Tween Bridge Solar Farm

Environmental Statement Appendix 10.1: Flood Risk Assessment Part 2

Document Reference: 6.3.10.1

**P21-3484 Tween Bridge Solar Farm - proposed flood risk management measures
Land either side of the M180, High Level Banks (the A18) and the Stainforth and
Keadby Canal**

Figure 2.6: Indicative Layout and Cross Section Plans
Drawing Ref: Typical Fence Detail - Ditch Crossing

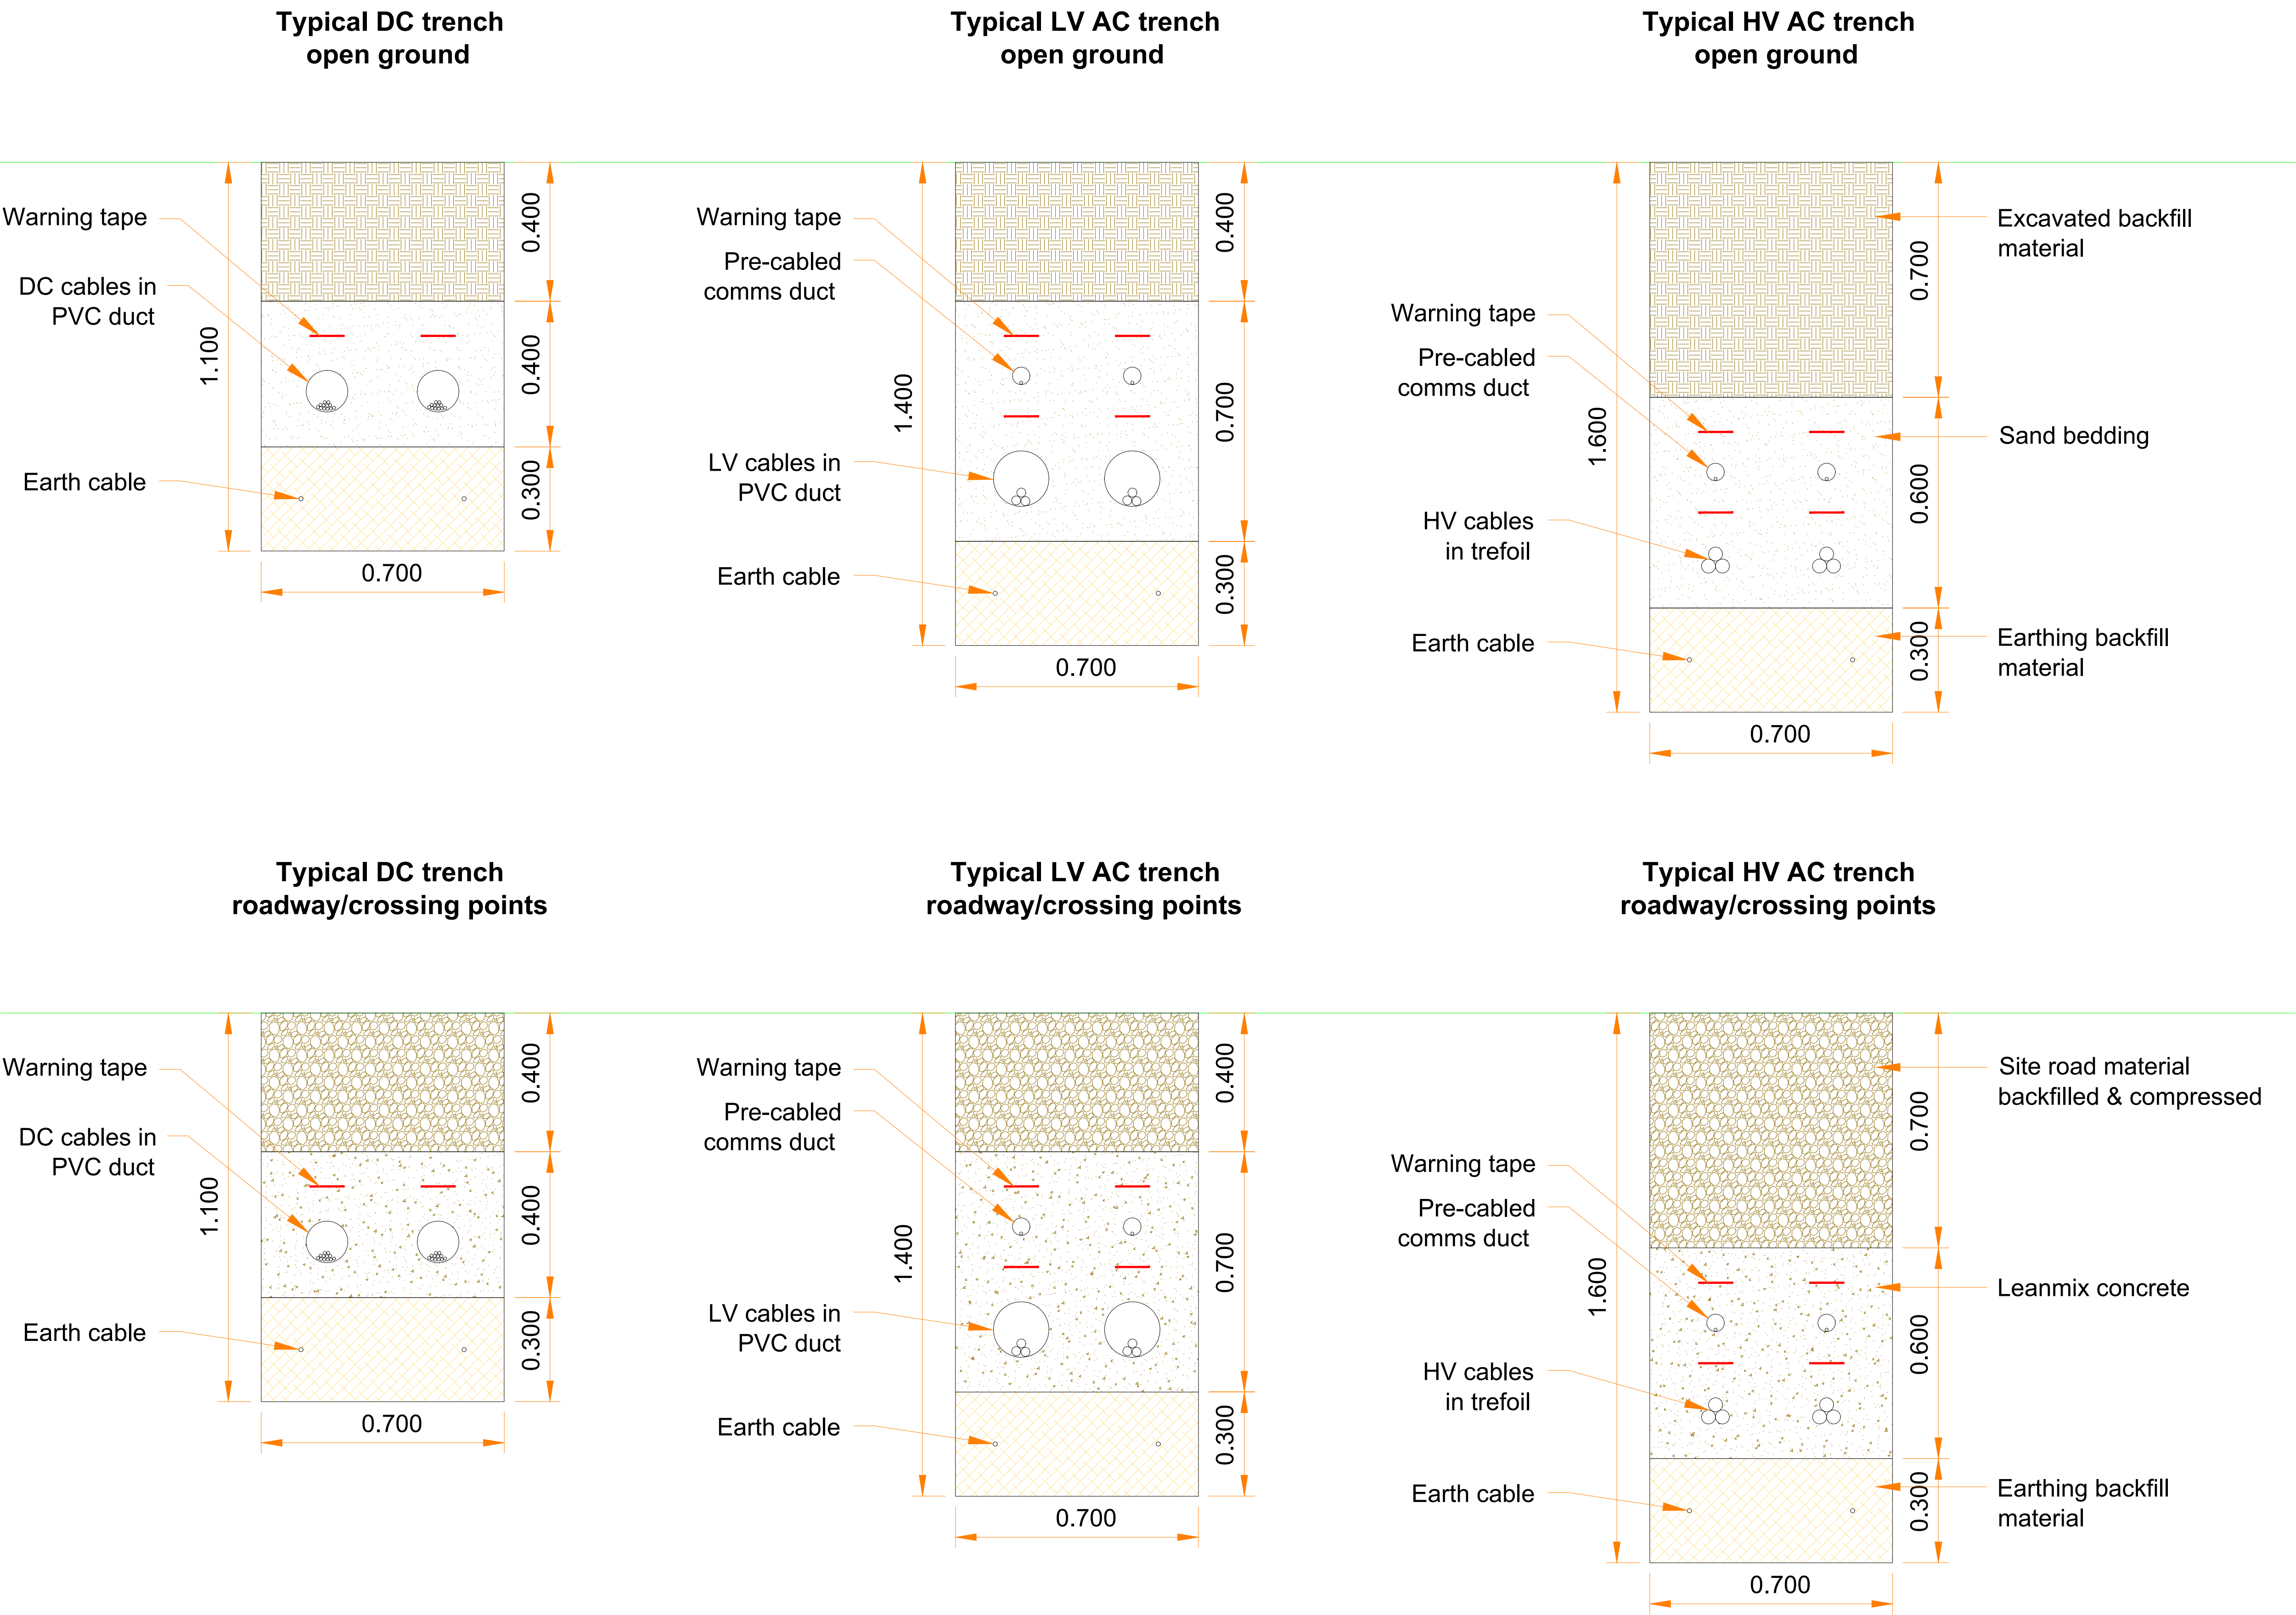
- The proposed method of fence crossings over ditches on site is also included in the ancillary drawing pack. We would welcome your comments on these proposals.

We cannot comment on whether these will be allowed, as these are not proposed on main rivers where we would normally insist on a FRAP. However, any fencing proposed within the floodplain should have a sufficient grid size if this is for the proposed mesh fencing or gaps for the proposed ditch crossing metal work, to allow the free flow of water across the floodplain. We would wish to see the proposed maintenance plan to provide comments on the proposals. Regular inspections of the fencing and grates should be undertaken to clear any debris which may have become snagged and could present a diversion in floodplain flows.

Non-Intrusive Cable Crossing – Watercourse/IDB Drain/Main River/Canal

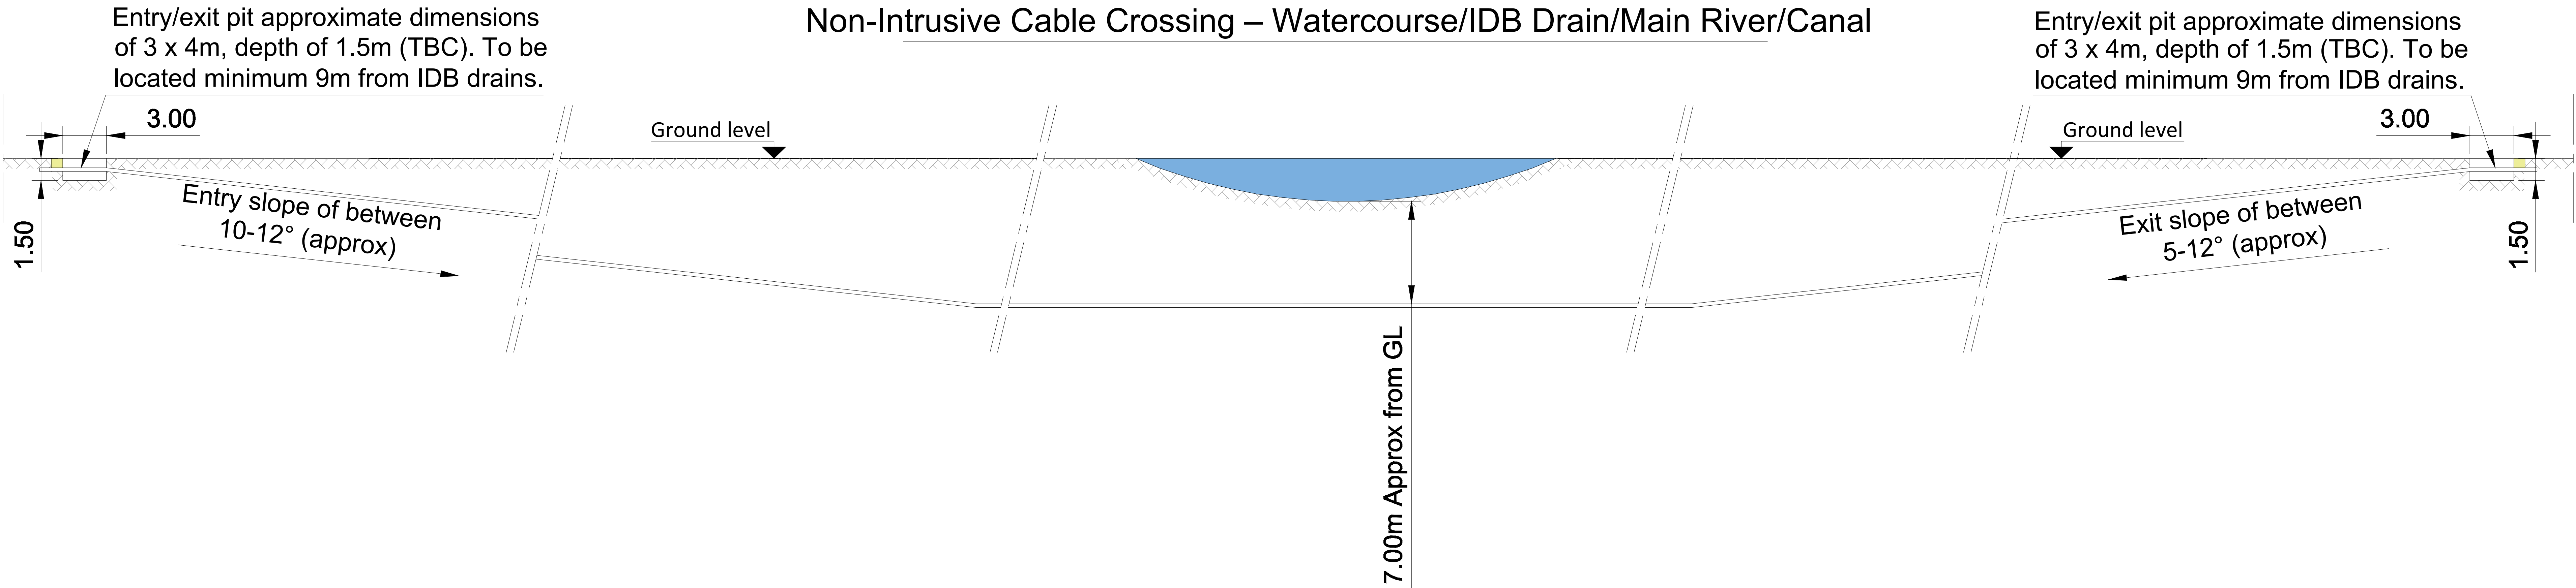
- The latest site layout plan linked above includes location of where cable route crossings are currently proposed (shown by yellow squares). The ancillary drawing pack includes typical plans of the proposed cabling methods for different scenarios. We would welcome your comments on these proposals.

Directional drilling under main rivers is covered by an exemption to the flood risk activity permit (FRAP) requirements, providing these can be undertaken in line with the exemption guidance. Where this is not possible then the applicant will require a bespoke permit.
